**Subject: Objection to SSD-14757962 Peninsula Solar Farm EIS**  
**Reference: SSD14757962**

I refer to the proposed Peninsula Solar Farm ('Proposal') (State Significant Development 14757962) to be located within the Forbes Shire Council Local Government Area. Council thanks the Department of Planning and Environment for the flexibility in the receipt of Council's submission due to the additional burdens placed on our community with regard to the significant floods we are experiencing.

**Figure 7** Sight Distance Assessment - Proposed Site Access

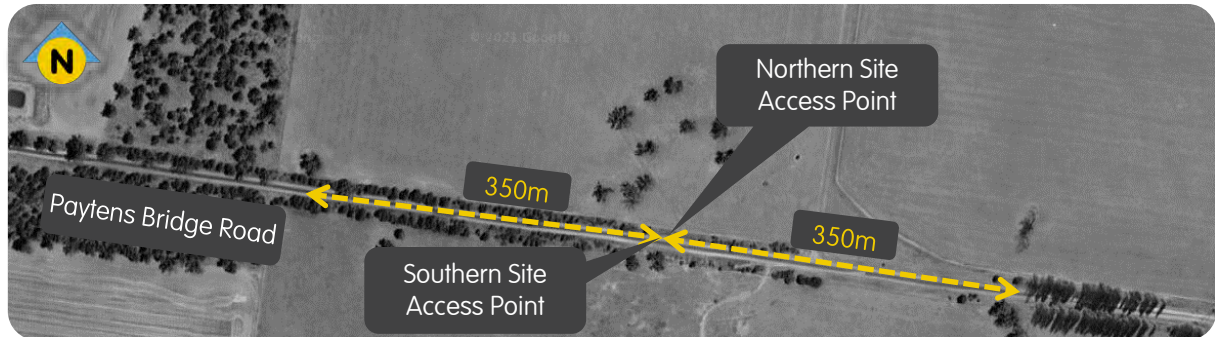
As all traffic movements in relation to the development will be entering the site via Payten's Bridge Road, the access must be designed as a Basic Left/Basic Right intersection treatment in accordance with *Austrroads Guides to Road Design*. Furthermore, the proposed access is located on a crest where site distance is limited. A BAL/BAR is the most basic intersection treatment provided in *Austrroads* and due to the movements associated with the development is a minimum requirement.

Furthermore, this section of *Austrroads* states that accesses should be designed for the largest vehicle likely to use them. As the applicant has not provided this detail, an adequate assessment is unable to be made.

Council requests that the TIA is amended to include a full and thorough assessment of the property access in accordance with Section 7.2.3 of Part 4 of *Austrroads Guide to Road Design*. Council is unable to support the development until such a time as the property access is thoroughly considered.

**Figure 9 Warrants for Turn Treatments at Unsignalised Intersections**

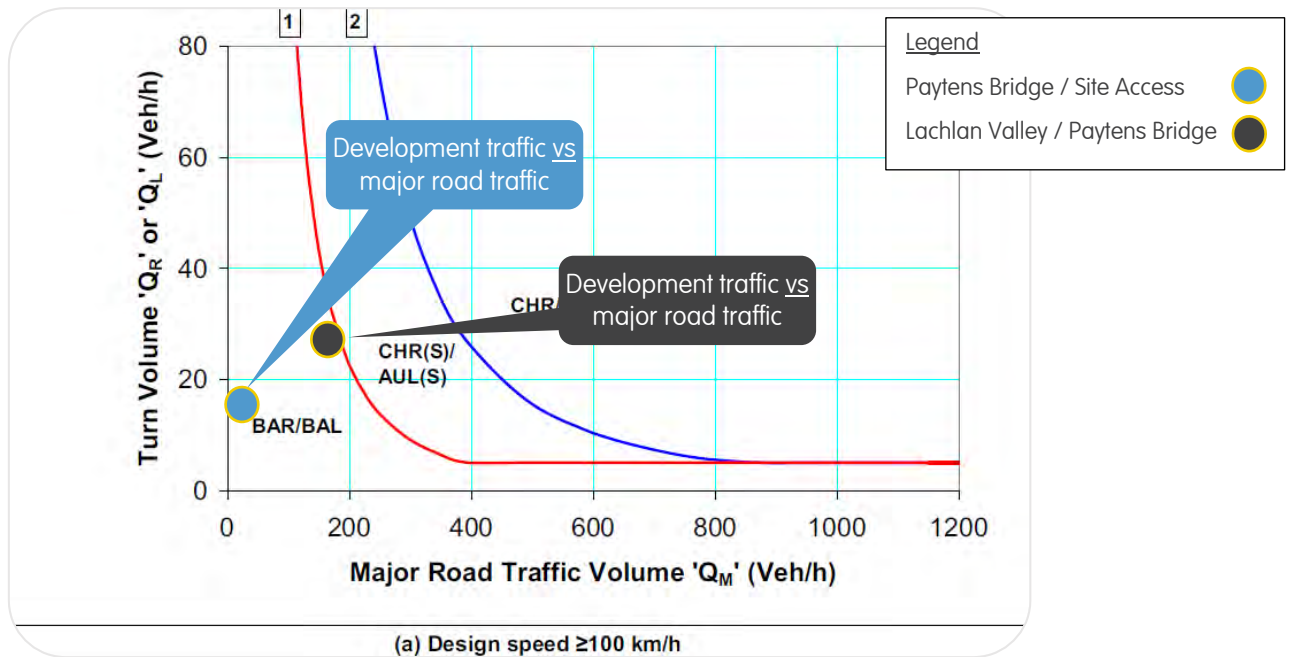
- Figure 9, Clause 5.3.2 must be updated based on actual traffic data;
- Clause 5.3.3 states that no data is available for traffic on the Lachlan Valley Way. Council requests this is amended to estimate 500 vehicles per lane per day, and Council would be willing to undertake traffic counts (at a cost to the applicant) to assist in this assessment;

Title  
CONCEPT LAYOUT PLAN - BAR TREATMENT  
LACHLAN VALLEY WY & PAYTENS BRIDGE RD

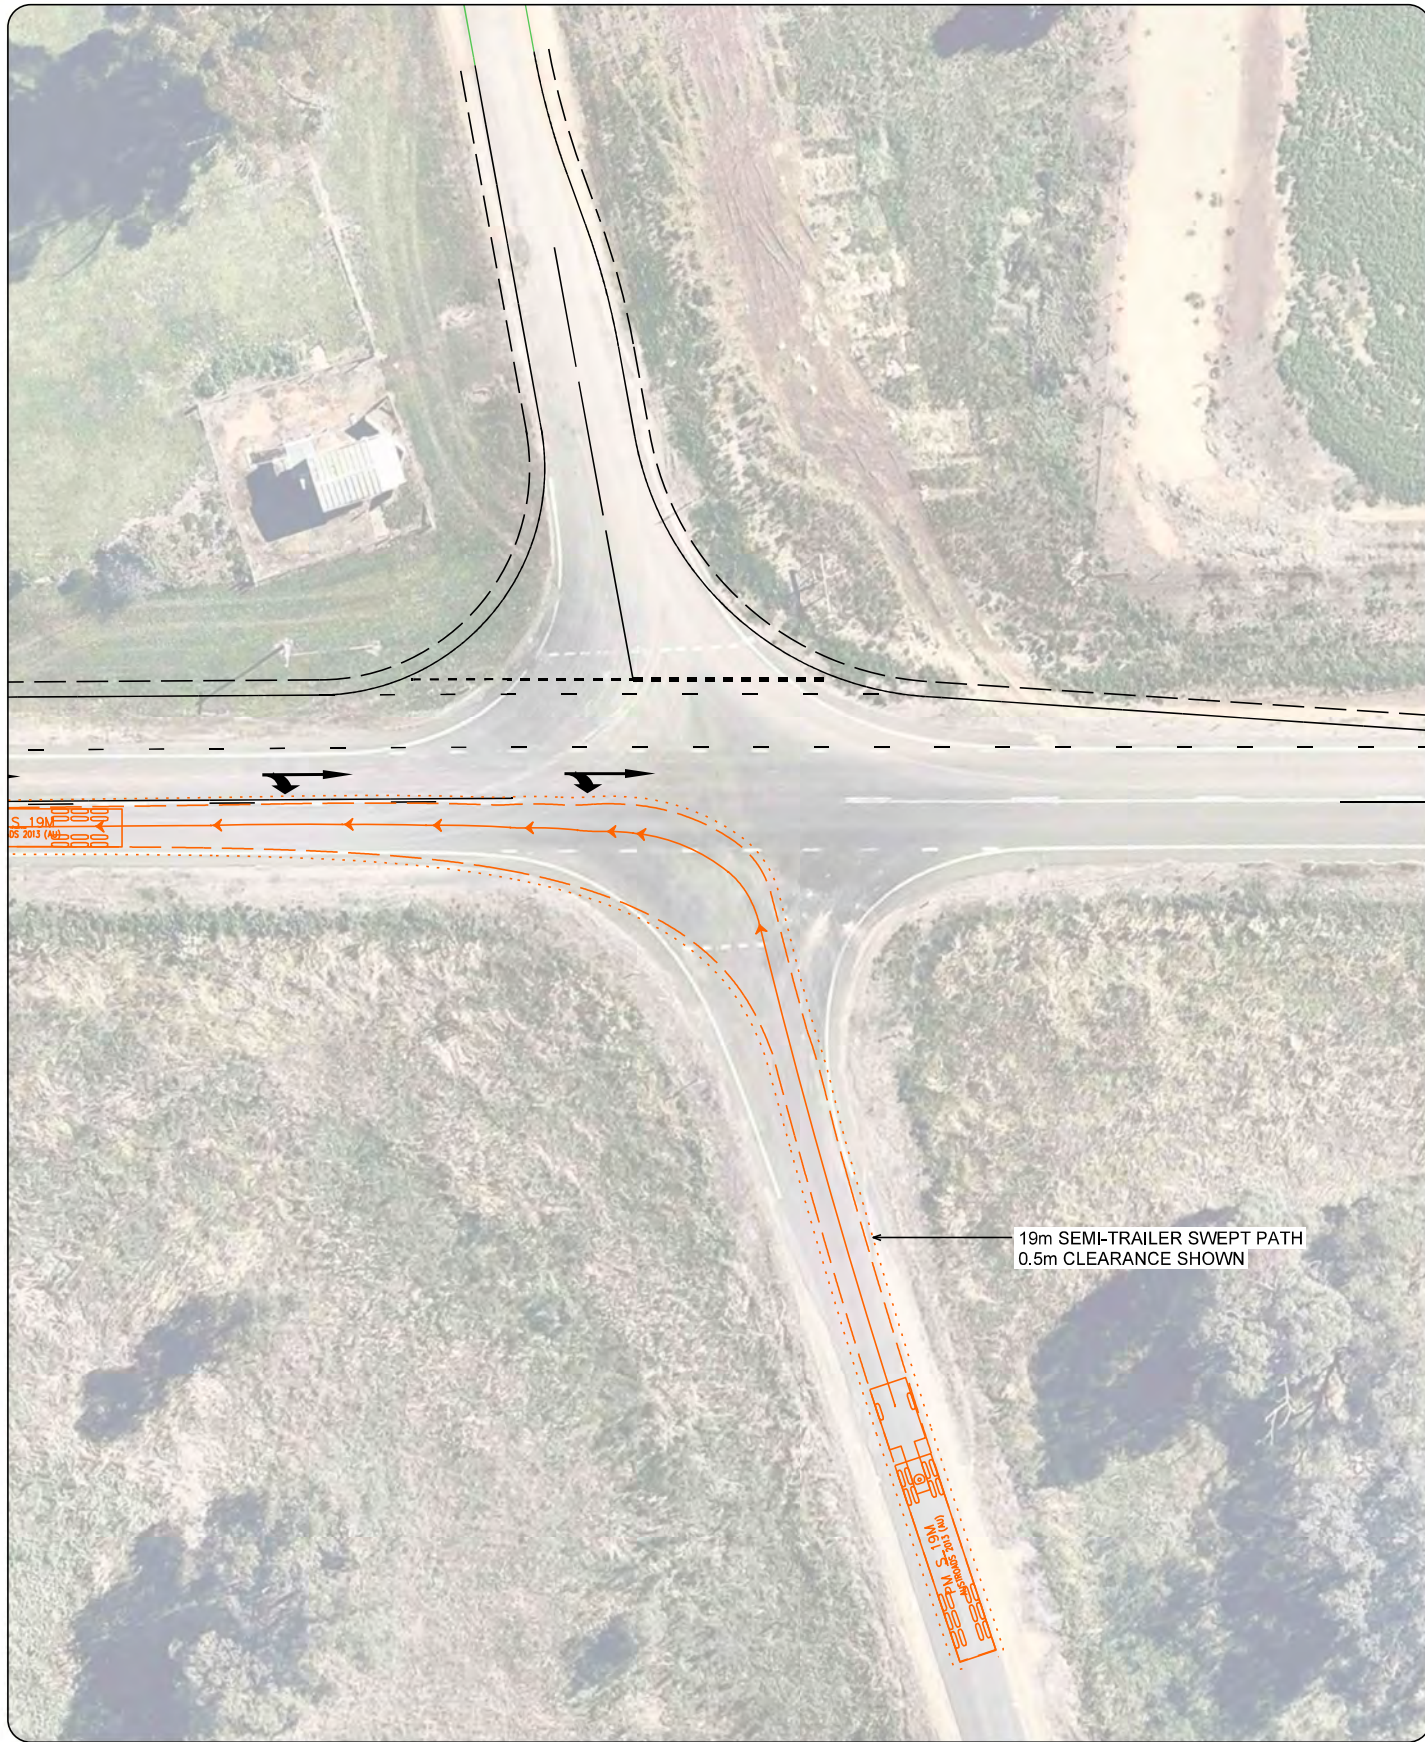
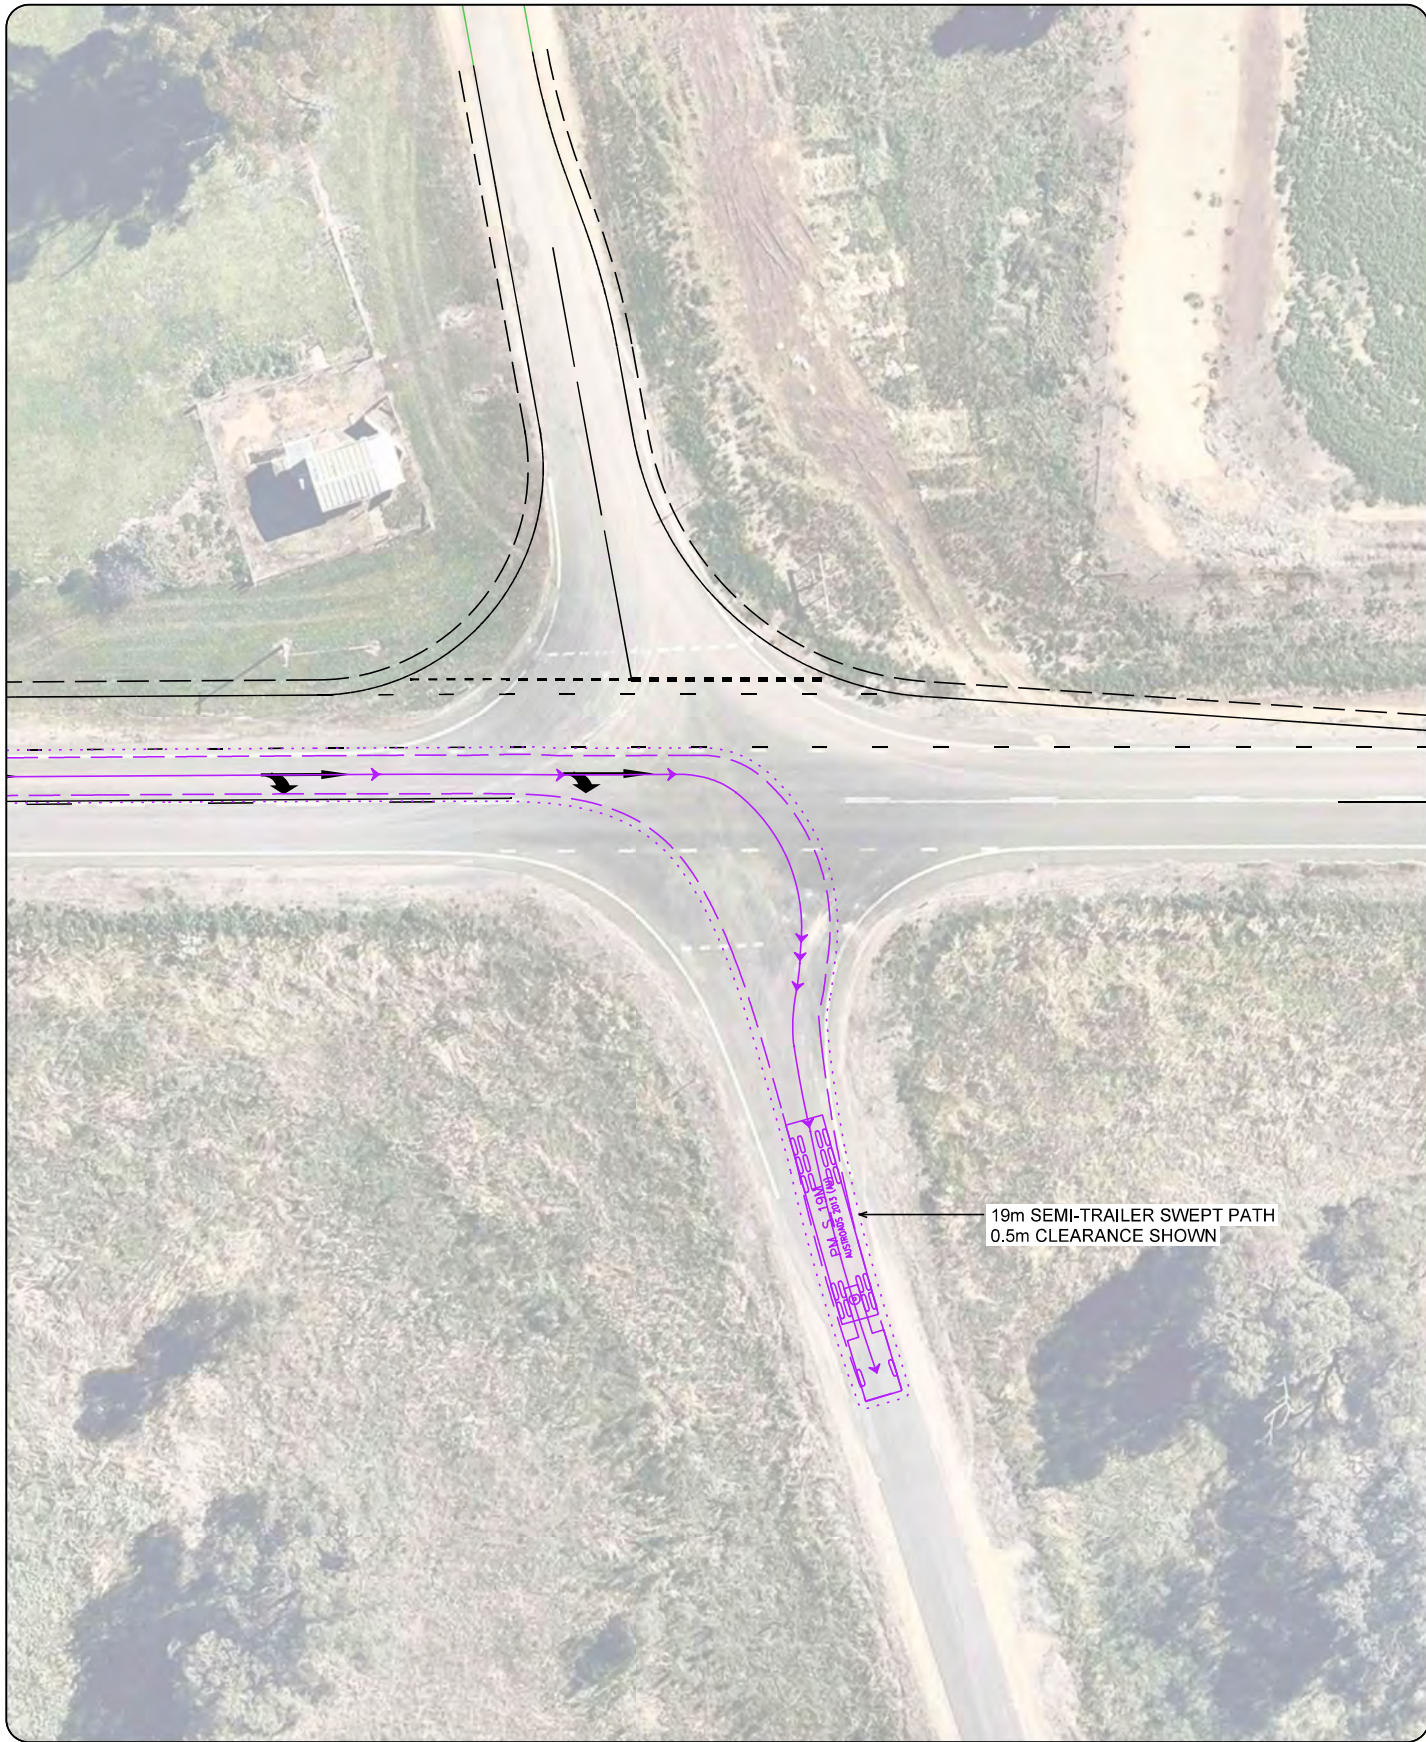
The Traffic Impact Assessment provides two separate intersection treatments at the Lachlan Valley Way and Payten's Bridge Road Intersection, depending on whether movements will be available via rail. The TIA also does not consider acceleration lanes for vehicles exiting Paytens Bridge Road.

Details are required as to when confirmation that rail will be available is required. This intersection was the site of a fatality in a vehicle turning left from Payten's Bridge Road onto Lachlan Valley Way.

Significant assessment of this intersection is required prior to the determination of this development application, and Council objects to the development application until such a time as this has been satisfactorily addressed. In particular, Council requires the following to be addressed:

- Historic fatalities and major accidents at or in the vicinity of this intersection;
- Safe Intersection Site Distance Analysis, in particular when observing westbound traffic on the Lachlan Valley Way;
- Impact widening of the road may have on surrounding landowners (ie, is there enough land in the road reserve to accommodate widening the intersection?); and
- The potential conflict of a four-way intersection, and its compliance with *Austrroads Guide to Road Design*.

Council wishes to inform DPE that it is likely a full CHR/AUL with appropriate acceleration lanes will likely be required in accordance with *Austrroads Guide to Road Design*.
